Engineers Comments Regarding Surface Water Drainage

Application Reference:	LU/8/26/PL	Reviewer Reference:	ADC/EXT5/AF
Planning Officer:	Kathryn Welch	Date of Review:	10/04/2026
Site Name:	St Catherines Roman Catholic Primary School Highdown Drive Littlehampton BN17 6HL		
Application Description:	Replacing part of the school field with a Multi Use Games Area (MUGA) - 92sqm of Duralawn surfacing with football pitch marking, 3m high fencing and gate, removal of existing wooden climbing frame and installation of 69sqm of Duralawn surfacing and 3 new wooden activity frames, tarmac resurfacing of 145sqm school playground with new line markings. This application is in CIL Zone 4 (Zero Rated) as other development.		
Assessment Number:	1

PROPOSED MUGA

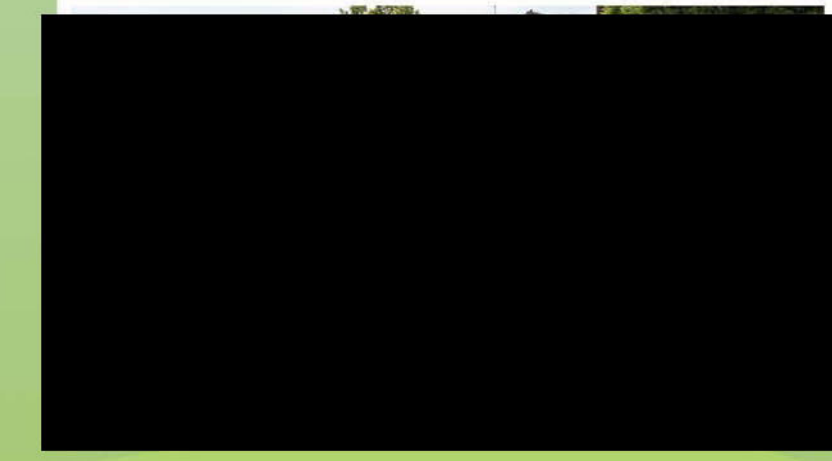
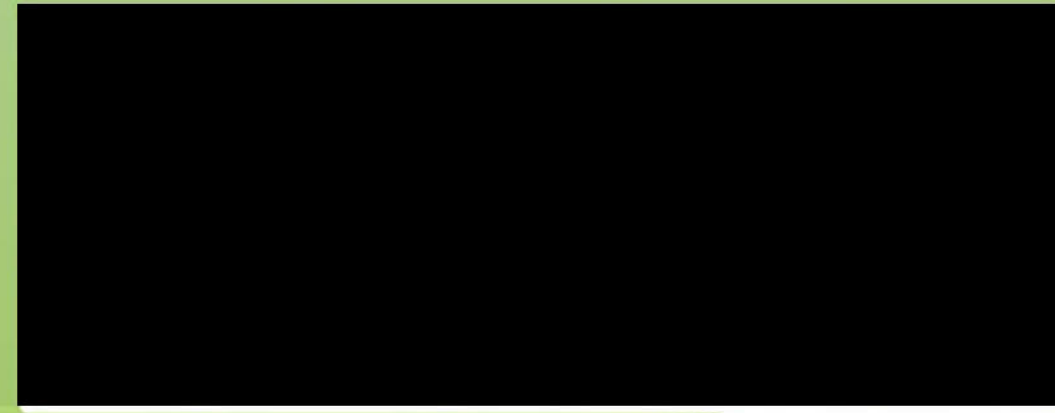
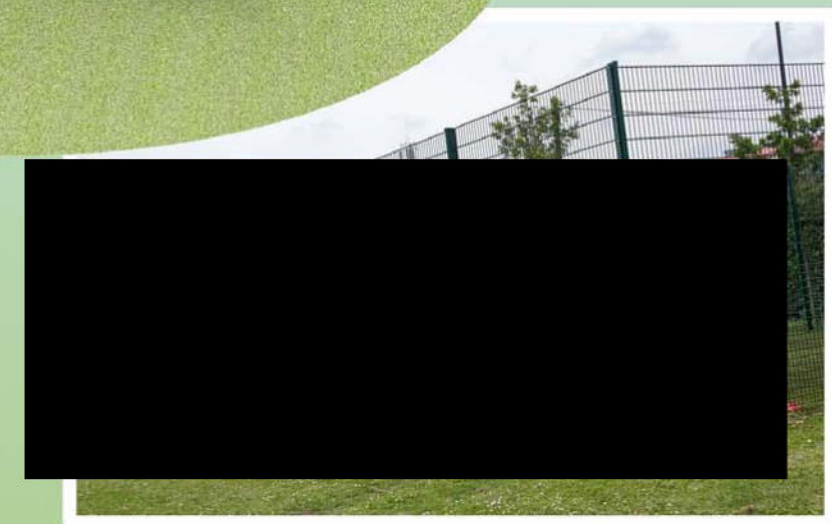
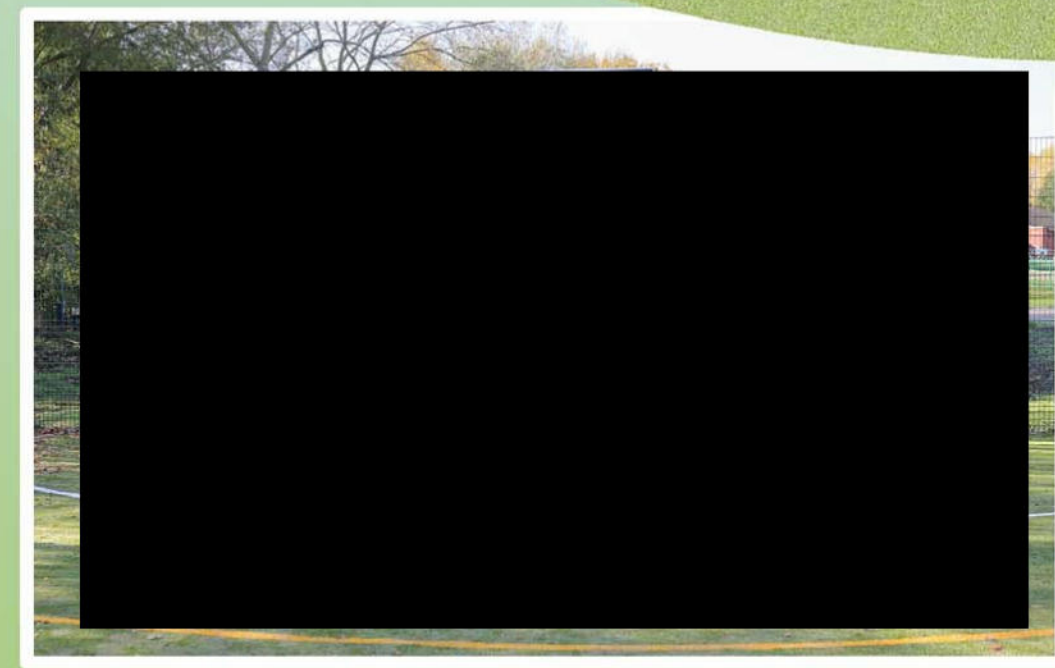
- 0.1. Whilst the proposed MUGA covers an area similar to the existing tarmac playground, the additional pitches are not natural grass and the engineered surface will require drainage. Therefore the development will require sustainable drainage in accordance with NPPF Paragraph 182.
- 0.2. The development is non major and the measures should be proportionate to the nature and scale of development.
- 0.3. A Sustainable Drainage Statement [SDS] is submitted in support of the planning application, together with the EA Flood Map for Planning which shows the present day flood zones for rivers and seas.
- 0.4. Note the site is within the outline of the EA future year flood risk zones from rivers and seas (Flood Zone 2 without defences) but is unlikely to raise issues of safe development and is not a Sequential Testing requirement.

- 2.1. Interception drainage would be provided by self-drained permeable surface, whether discharged to ground or conveyed to an outfall.
- 2.2. The current design appears to convey runoff from the pitches to an infiltration blanket beneath the MUGA, but it appears from the preliminary details the pitch surface may also be permeable.
- 2.3. The design should be clarified once the runoff destination is confirmed to ensure the proposals meet NSfS Standard 2.
